Subject: Re: Van Soest Property Meeting

Great news, I talked with Ann and it she said she will be OK with granting an staff-level waiver for the rear property line setback based on the plan you provided (with the closest point being approx. 16'). This means you won't have to do the variance or change the lot lines, if you stick with the plan as shown. Can you remind be of what the dimensions of the deck will be? I will put a note in the property file as a reminder of the waiver for when the permit application comes in.

SITE PLAN DETAIL

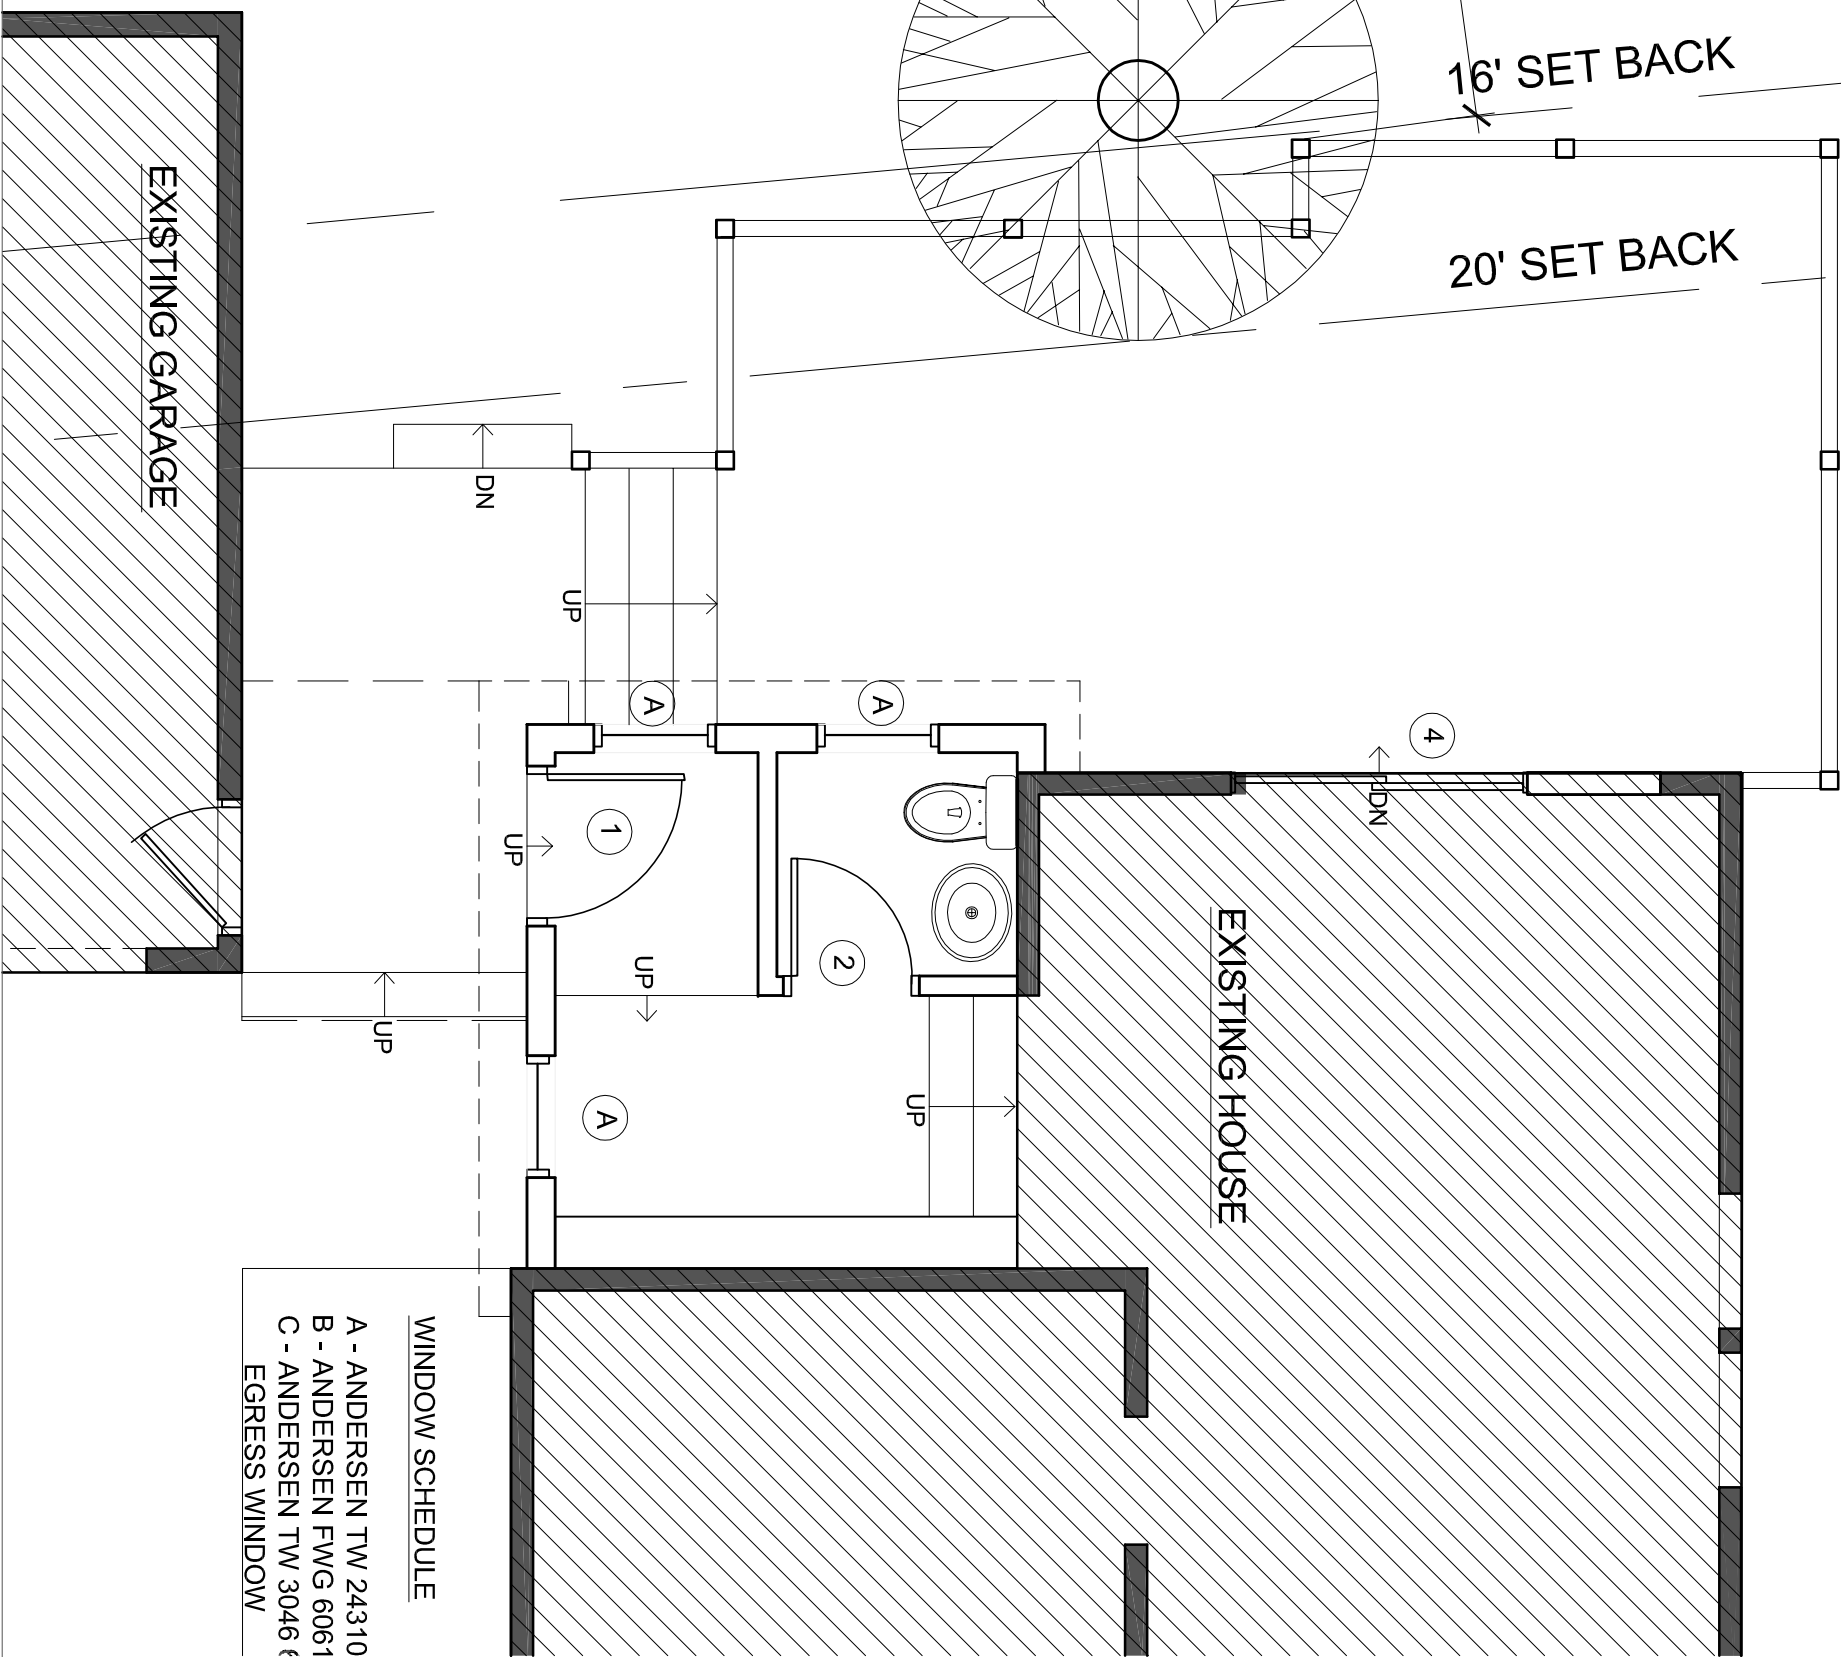
Yes, I was referring to the steps that go from the large deck down to a lower deck(?) that will abut the garage.

The other new structures (bathroom and the smaller stoop/deck) are going to be at least 20' from the rear line, correct? If so, I think you should be all set for zoning. I don't think there is any need for us to meet; at this point it is a matter of submitting your permit application and going through the process!

Attached is a modified drawing showing the 20' setback as well as the 16'. I think this answers your question? The stoop and lower deck are outside 20'.

When drawing I considered all the deck structures (except for what is right in front of back door) part of the "deck" and so had in mind the 16' limitation only. However, the stair and surface below it should be 20" away.
